KIRKLEES METROPOLITAN COUNCIL INVESTMENT & REGENERATION SERVICE

DELEGATED DECISION TO DETERMINE PLANNING APPLICATIONS

Reference No:	2026/62/90733/W
Site Address:	54, Meltham Road, Lockwood, Huddersfield, HD1 3UP
Description:	Change of use from dwelling (C3 use) to form 2 residential apartments (C3 use)
Recommending Officer:	Elenya Jackson

DECISION – REFUSED

Drawn No.
101

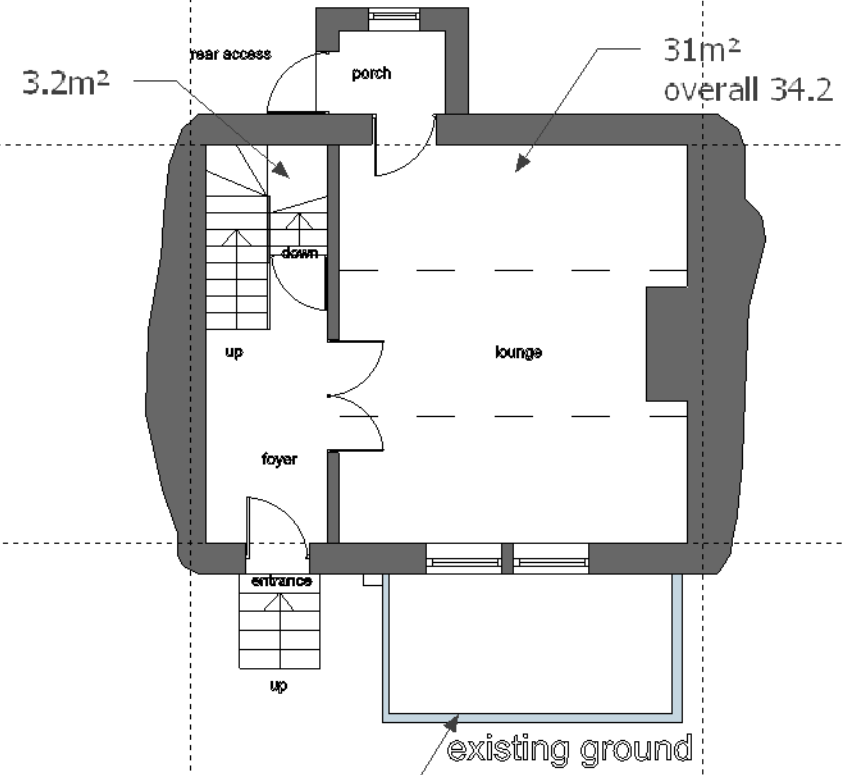
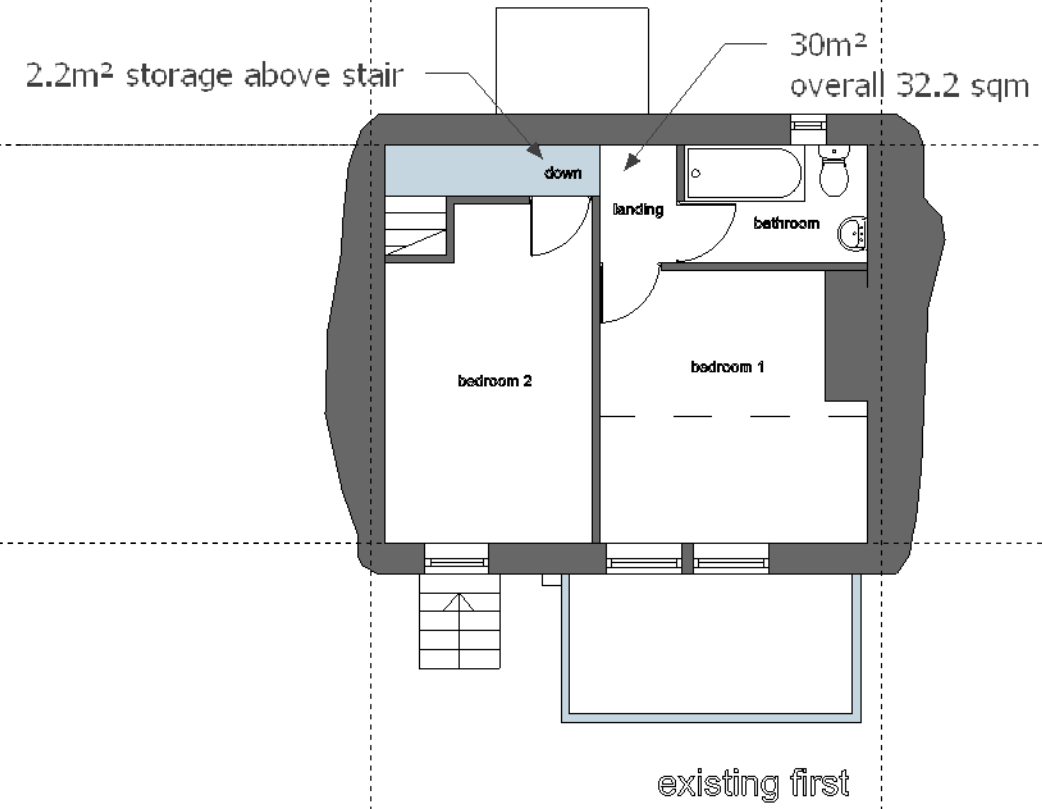
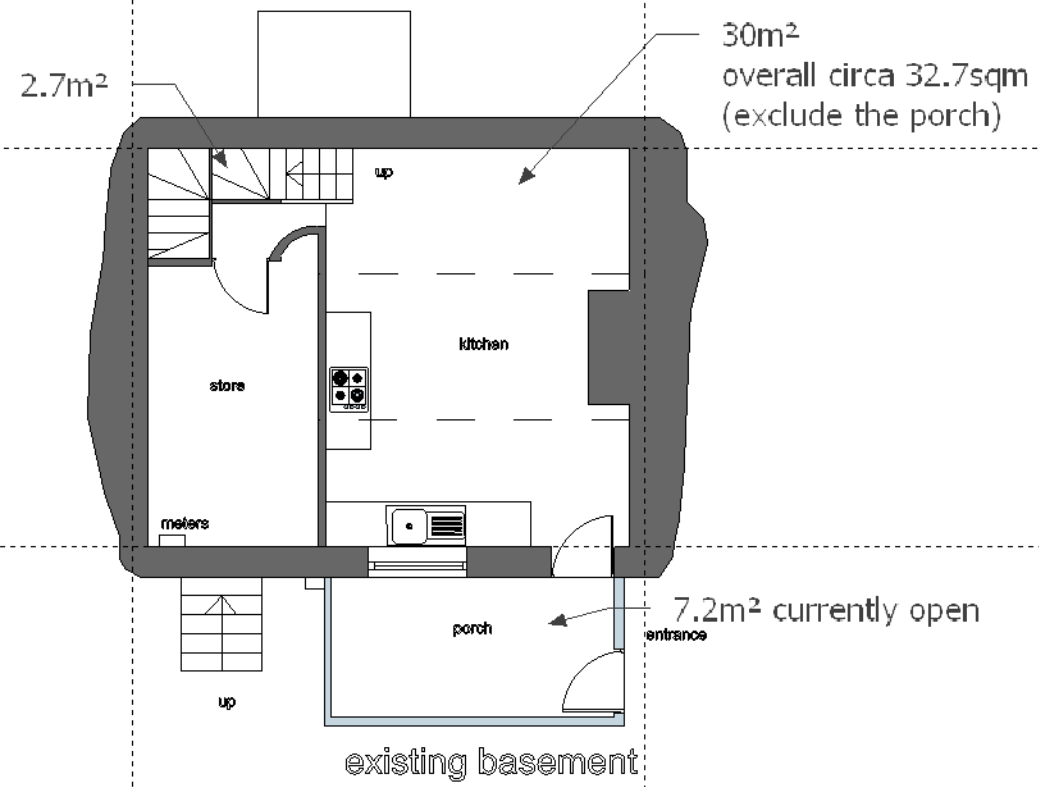
This conclusion is drawn having cognisance of the fact the proposal would see an existing unsympathetic structure to the front of the host property repaired to be utilised as part of the scheme. The description of the development is change of use only, the works for repair and maintenance of existing structures and the building would likely fall within the extent of works for which an application for planning permission is not required.

Drawn No.
103

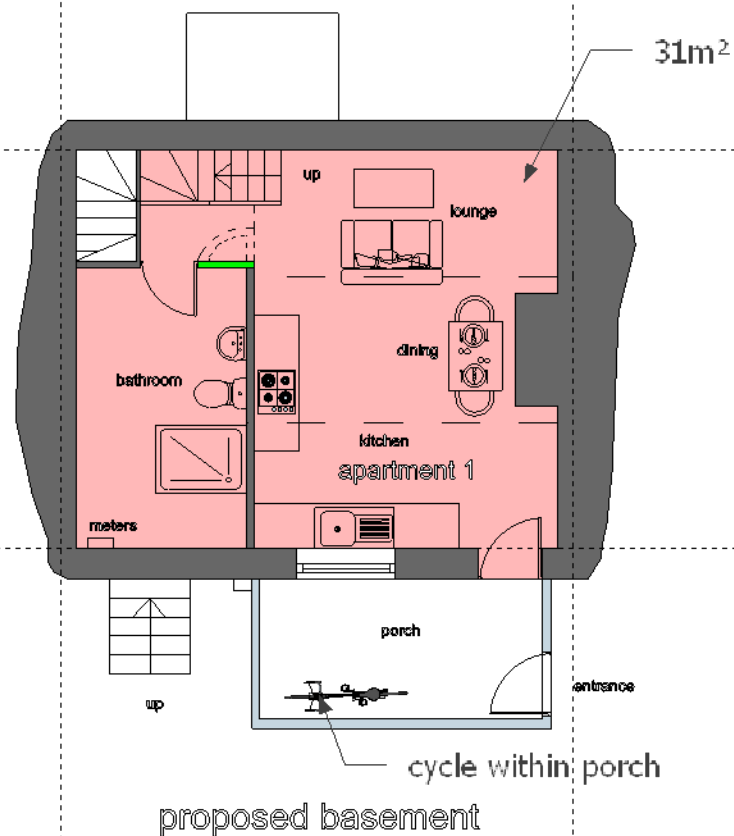
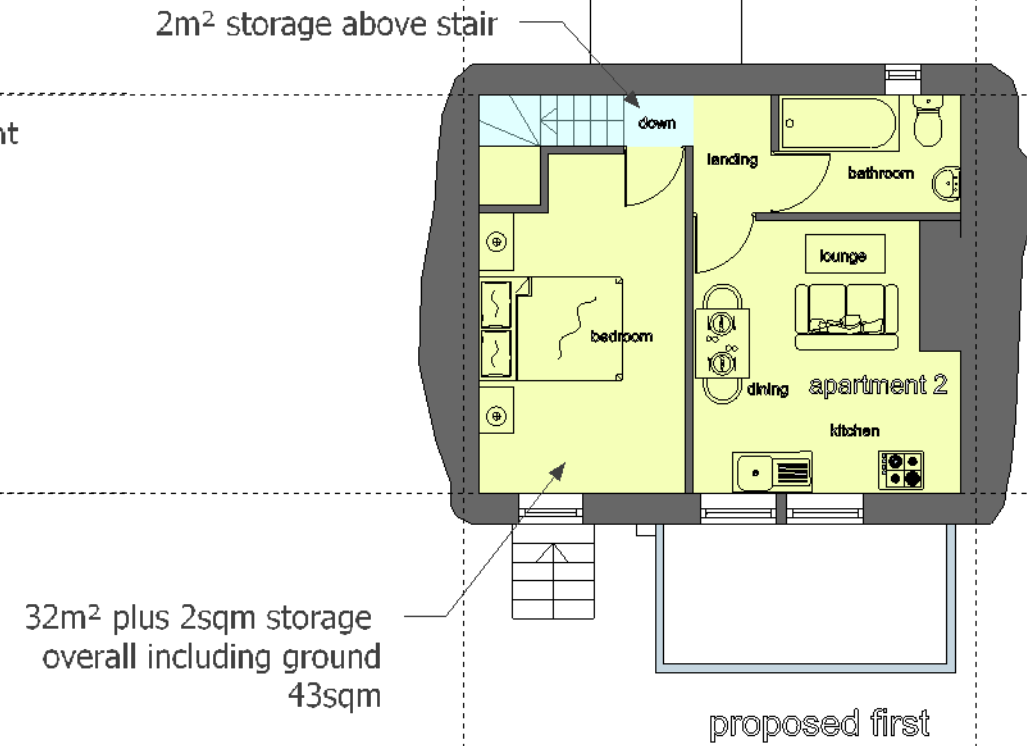
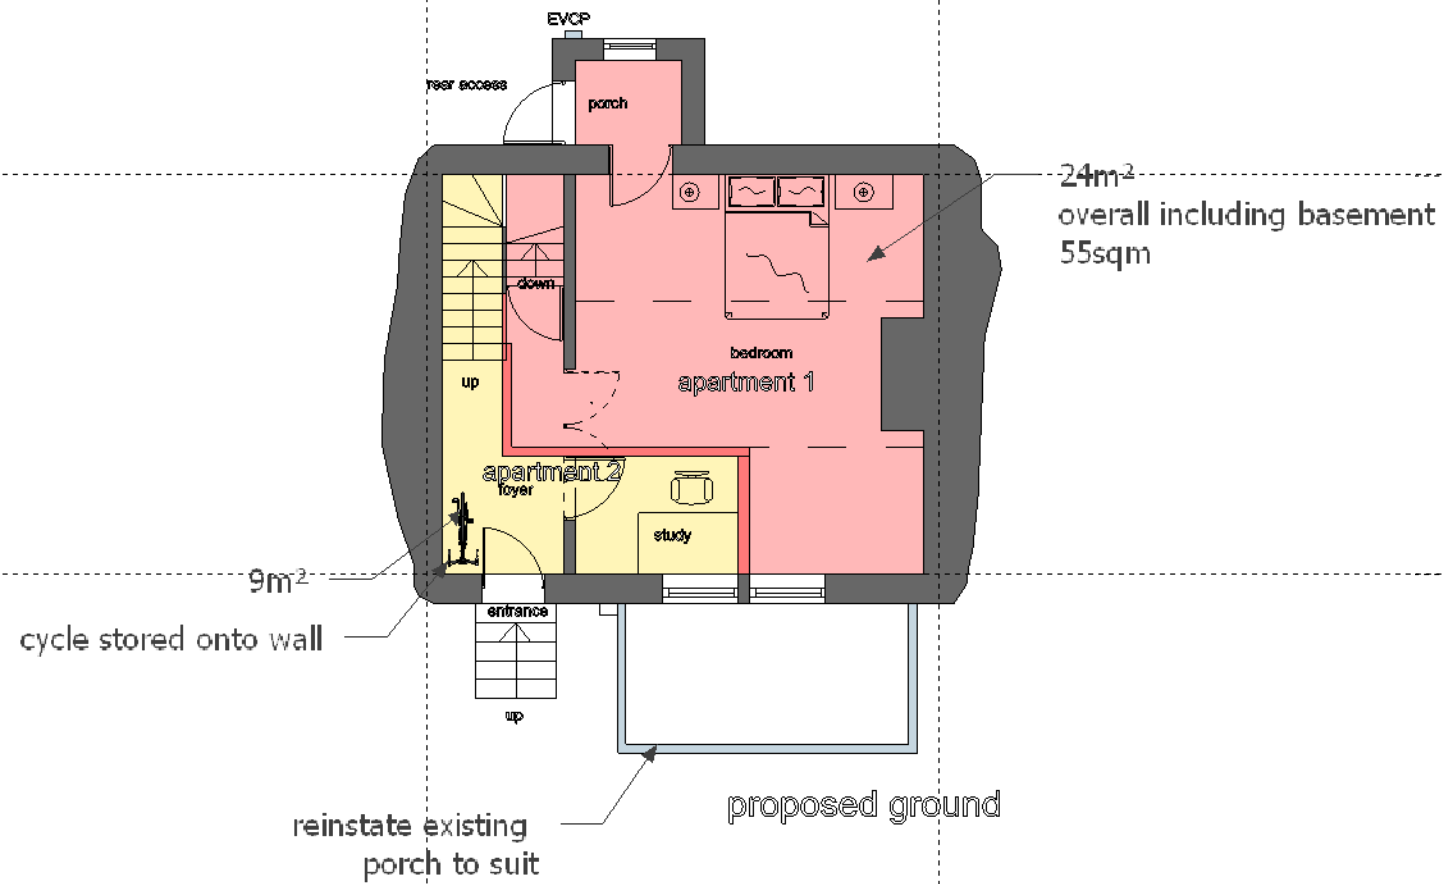
Both flats would have one bedroom and would be set over two storeys and therefore would be required to have a footprint of 58m². The floor plans demonstrate the flats would have a footprint of 43m² and 55m² which would fall short of space standards.

The outlook for the living space for the dwelling annotated ‘Apartment 1’ is solely from a window which will be facing into a porch structure. Whilst the porch structure appears to be a translucent roof construction the outlook for this dwelling would be limited and the provision of natural light restricted. Coupled with the shortfall in relation to space standards as required by principle 16 of the SPD it is considered that the impact to the amenity of the occupiers of this dwelling would fall short of that which would be expected to ensure an acceptable standard of housing environment. It is therefore concluded that the proposal would have a resultant unacceptable impact in relation to the residential amenity of occupiers of this dwelling despite the shortfall of the NDSS space standard being 3m² and this dwelling being the dwelling closest to achieving the space standard (yet still being short of the recommended standard).

The dwelling annotated ‘Apartment 2’ on the submitted plans is 15m² short of the recommended space standard (being 43m² with the standard being 58m²). Whilst better served in terms of windows and outlook and natural light being of a better standard than the dwelling annotated ‘Apartment 1’, the substantial

shortfall is considered to lead to a dwelling which would have cramped layout with a limited space for providing a usable living space in particular with this area combined with the kitchen facilities. As such it is considered that the proposal would have a resultant unacceptable impact in relation to the residential amenity of occupiers of this dwelling.

As set out earlier within this section, it is considered that the proposed development would not provide suitable floor space provision / layout arrangements for future occupiers of the development. The layout of the flats is constrained by the requirement for the floor space being spread across different floors within the property. Given the layout of the dwellings and resultant space for future occupiers it is concluded the development would have an unacceptable impact for the residential amenity of future occupiers of the development.
